From: Simon Davis
Sent: 17 July 2017 16:32
To: Planning.Responses
Subject: FW: CHECAA Objection (2) to AW/155/17/PL - Brus Lodge, 28 Kingsway - 12-7-2017. FRONT WALL CONSTRUCTION PLAN REQUESTED.
Importance: High

Existing + Proposed Street Elevation

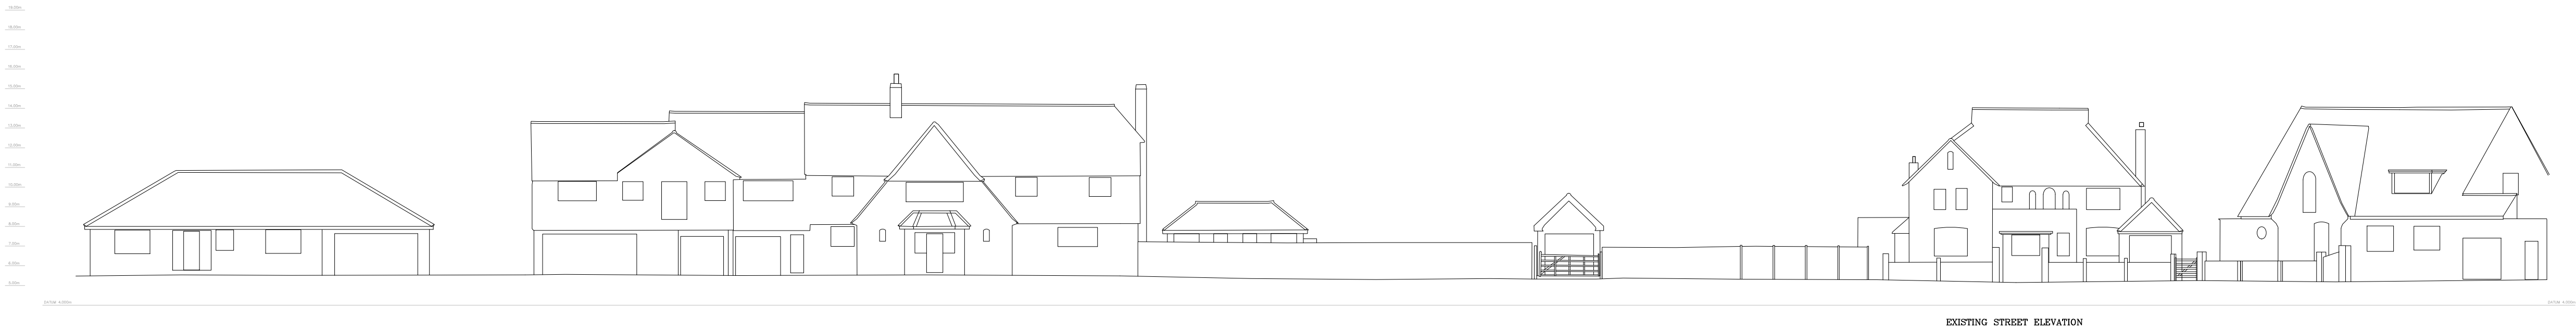
Uploading this to the website seems to have been overlooked and I have received no reply from you or any other. Can you please have a construction plan for the walls, gate piers and gates posted complete with measurements.

The design of the walls and piers is a very significant and material planning consideration in this sensitive part of the Conservation Area. Saying just 'brick' is inadequate!

We need to know the dimensions of the footings for the walls and piers and their accurate position in order to study their juxtaposition to all trees and shrubs.

Thank you for this information but it is our view that, far from being what you describe as being '...the proposed wall...' in the street scene this is, as is described today by the Conservation/Design Officer, no more than '...an indicative illustration...'. For Seaman to suggest that this is a scaled plan at 1:200 is ludicrous and certainly NOT the case – you are asking us to believe that those 5 houses, windows, roofs etc are drawn to scale is totally unrealistic and not the case!

Will you please receive and post on the website this further objection by CHECAA to AW/155/17/PL which calls for a fully detailed construction plan of the proposed front wall, including all dimensions and materials it is proposed to use including materials and colours of any gates, bricks and the like.

Thank you for your letter. I note that the design of the proposed wall is shown on the submitted streetscene drawing (dwg. TSP 481 PL25 A) and its dimensions can be scaled from this using the online tool. Furthermore, the application form indicates that new boundary walls will be constructed from brick. If permission was granted, a condition could be imposed requiring details of all materials including for the wall.
